From: [REDACTED]
To: [Hinckley SRFI](#)
Subject: Response to HNRFI additional information
Date: 04 February 2025 10:45:47

A summary of my feedback regarding the B4669 Hinckley Road/Leicester Road Sapcote issues is as follows:

A summary of my feedback regarding the proposed changes in the centre of Sapcote, surrounding the Co-Op is as follows:

Drawing Title
GENERAL ARRANGEMENT SHEET 18

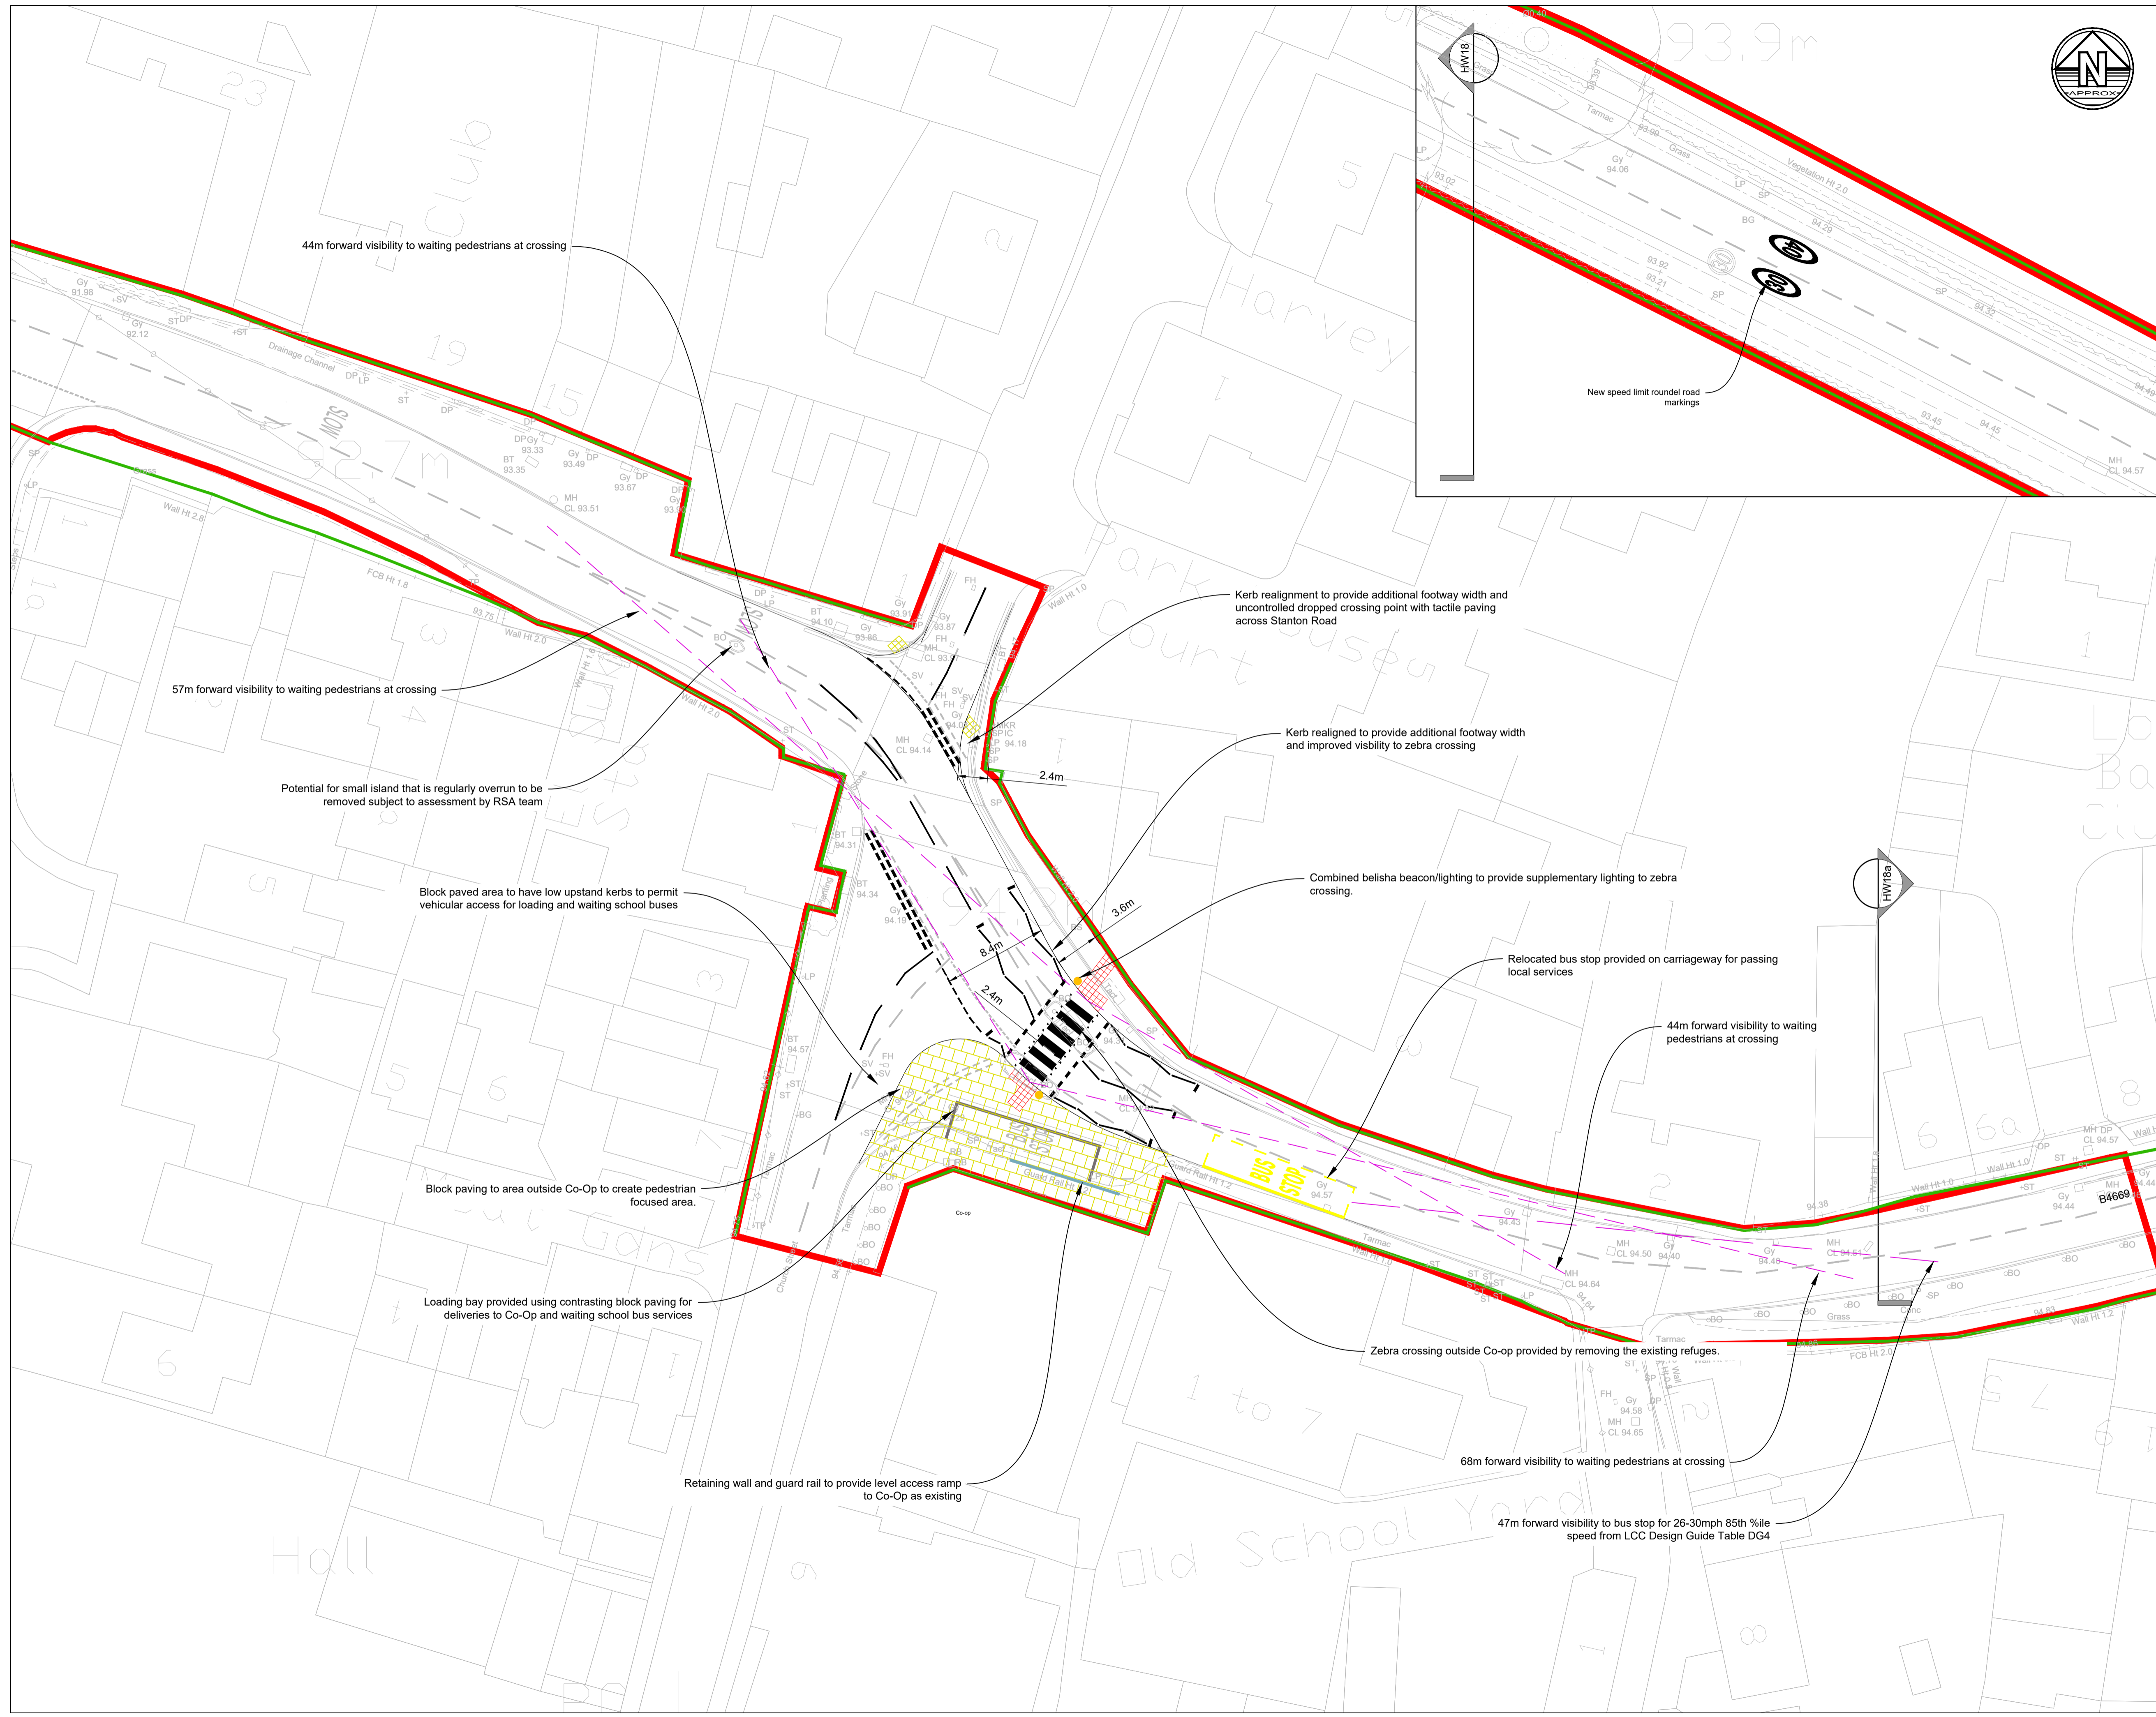
- There is a proposal to restrict parking on Hinckley Road. Most of the parking is outside a nursery and there is no alternative location for parking. The parking occurs all day, but it is particularly busy at drop off and pick up times with many cars and pre-school children. Stopping parking would significantly affect the business and endanger the children and parents attending the nursery. The village is expanding very rapidly, with many new young families, and the nursery is very busy.

- Narrowing the Hinckley Road/Leicester Road to restrict the number of Lorries coming through Sapcote is poorly thought out. There is no provision for what happens when there are two oncoming vehicles in the narrow part of the road, or for which direction has priority. There is no room for vehicles to wait and this will force a vehicle onto the pavement to avoid a collision.

- Pedestrianising the current bus lay-by outside the Co Op would cause more congestion on the planned narrowed road. At present the Co Op has four parking spaces and one disabled parking bay. Outside the Co Op is the ATM in the village and a parcel drop and collect unit. As such parking at various times of the day pose a challenge as residents and other drivers utilise these facilities. The proposals will force vehicles to park on the junction with Hinckley Road/Leicester Road and Church Street.

- Currently the bus stop outside the Co Op ensure children waiting for the school buses are away from the road on the side outside the Co Op. Moving the bus stop to a narrower part of pavement poses pedestrian congestion at times when there are children waiting for the bus, parents taking their children to the primary school on foot and other residents walking through the village. This will pose a risk of accidents
